Please find the below letter of intent for 10155 Chipita Park Rd., Cascade, CO 80809.

3. **Request and Justification:** We are requesting permission to build a new garage with walk-out upper level guest house within the front setback but further back than the existing garage. Due to site limitations and the need for safe off street parking we are requesting a setback variance.

SITE PLAN

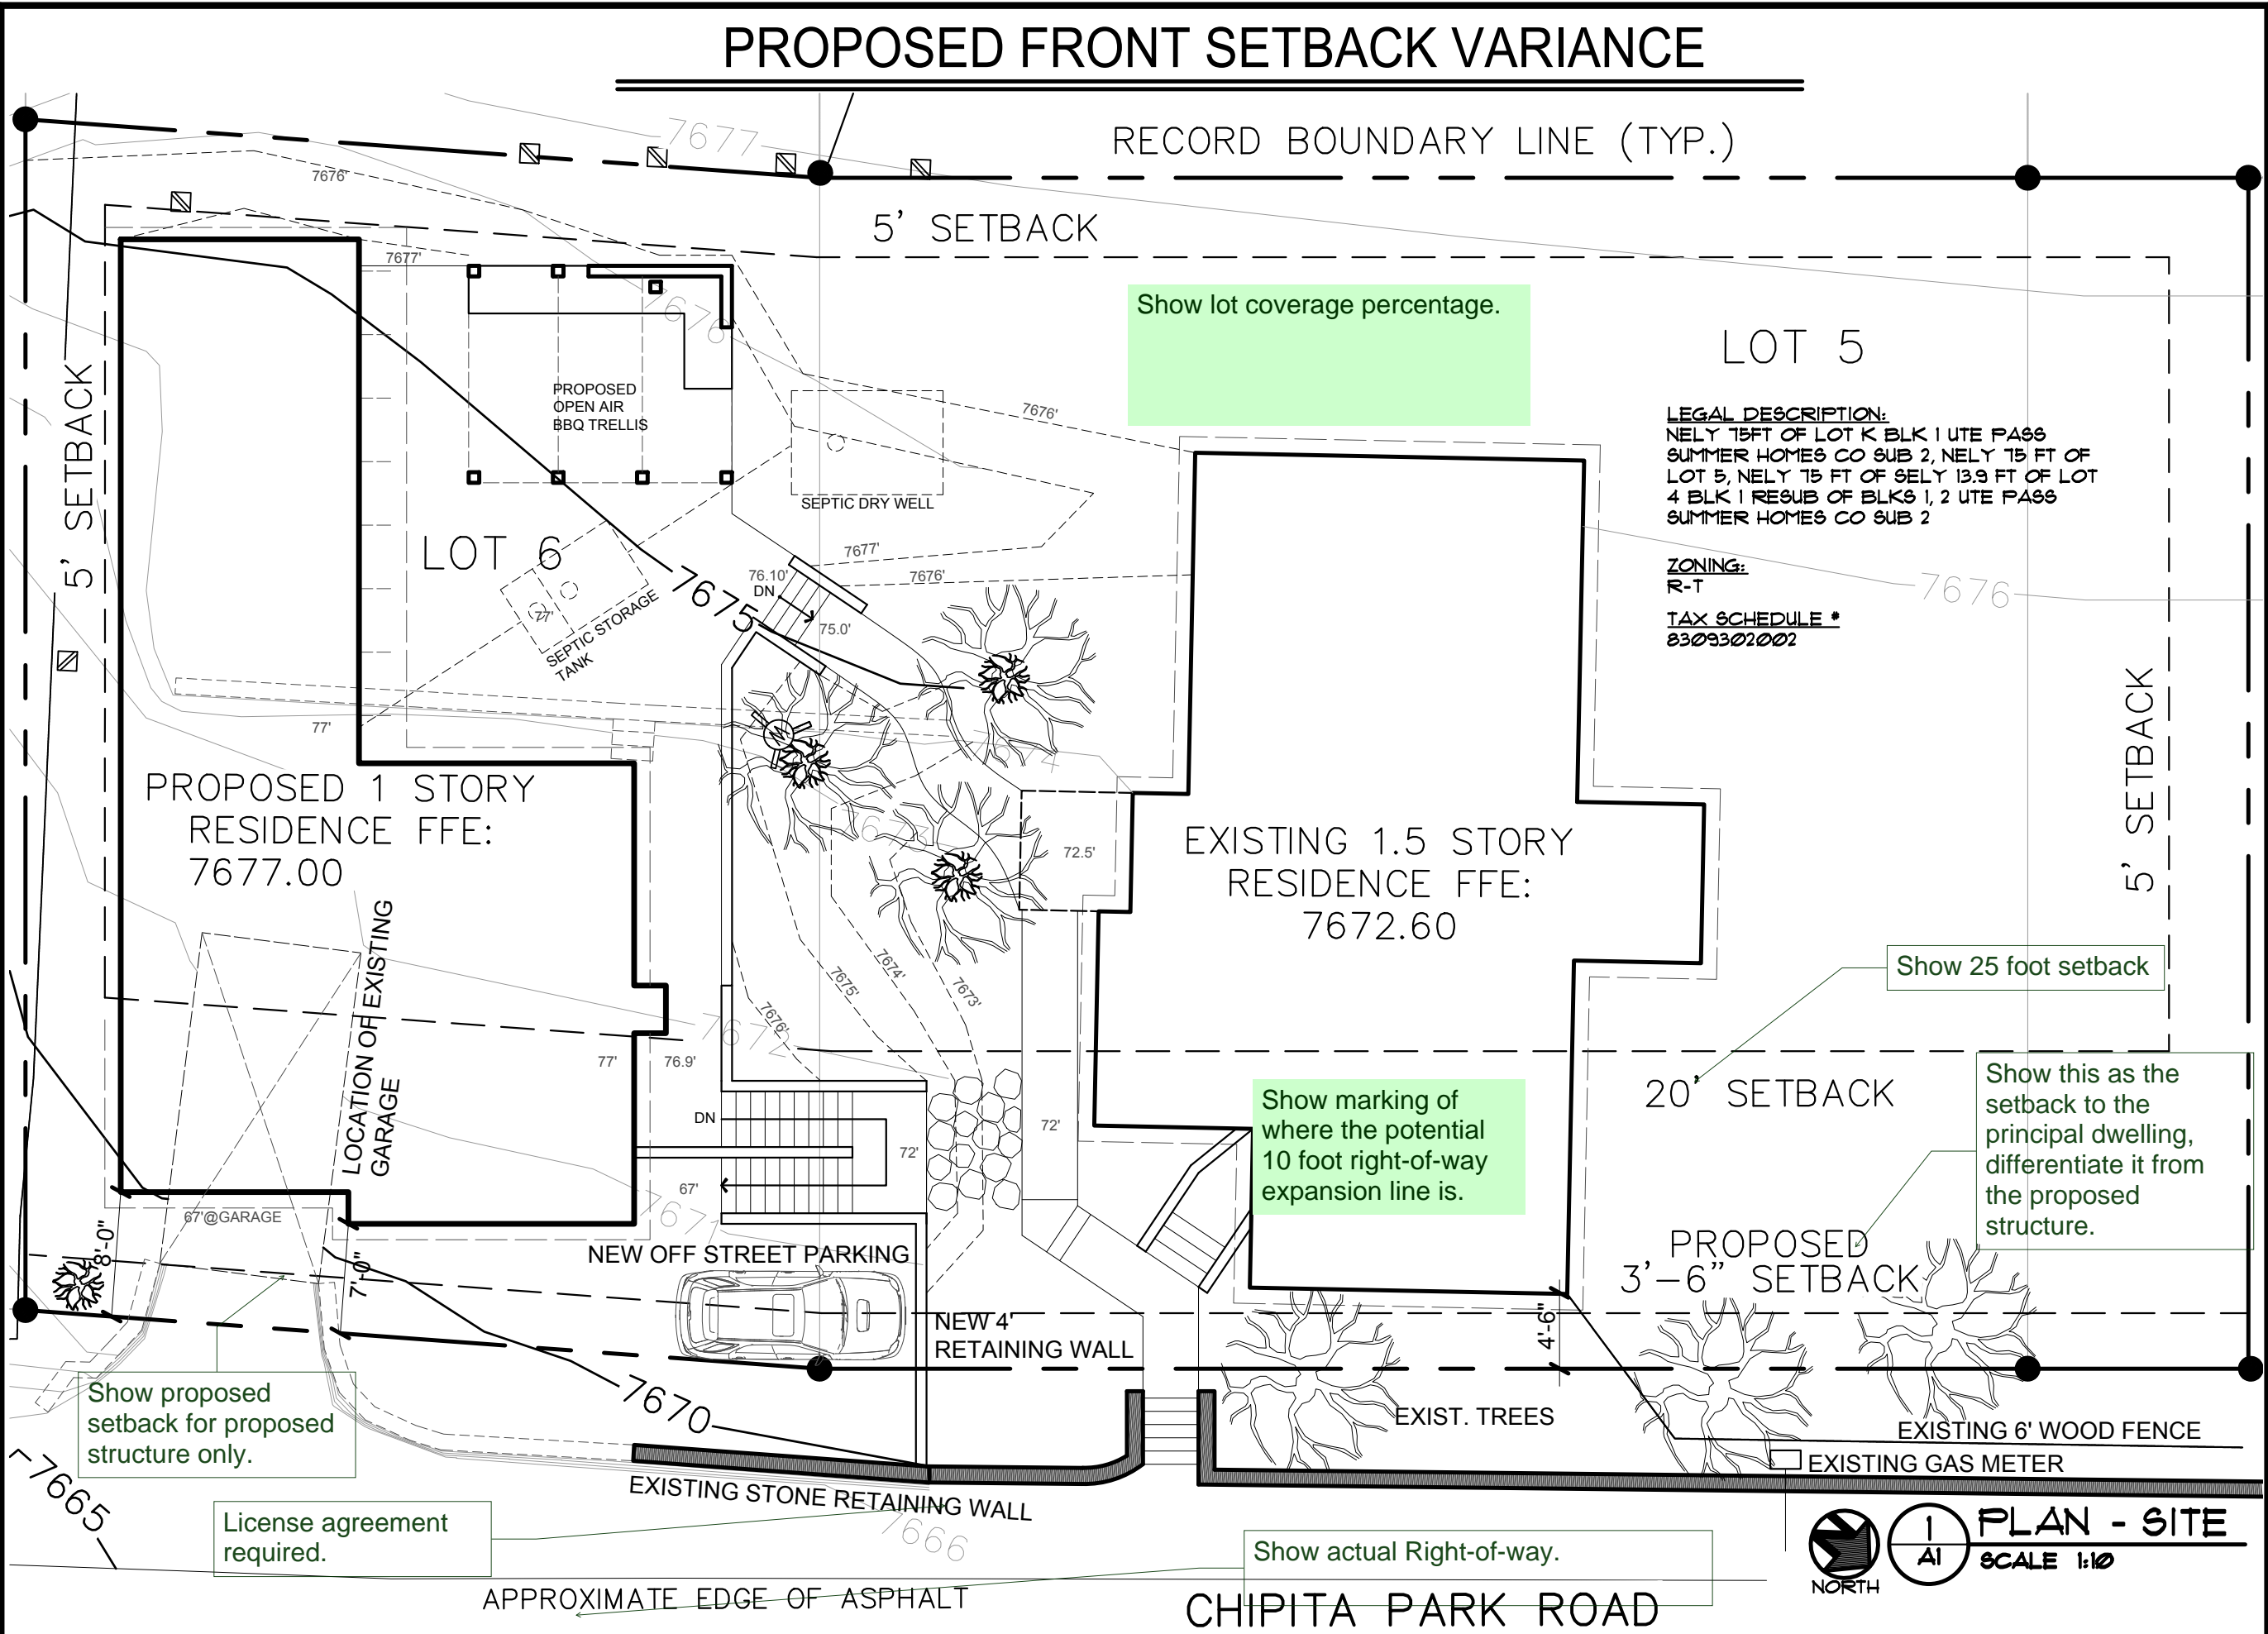
State what will happen to the existing garage.

Go over the right-of-way issue.

Delineate the existing house setback to the structure, and the proposed setback(s) of the proposed structure.
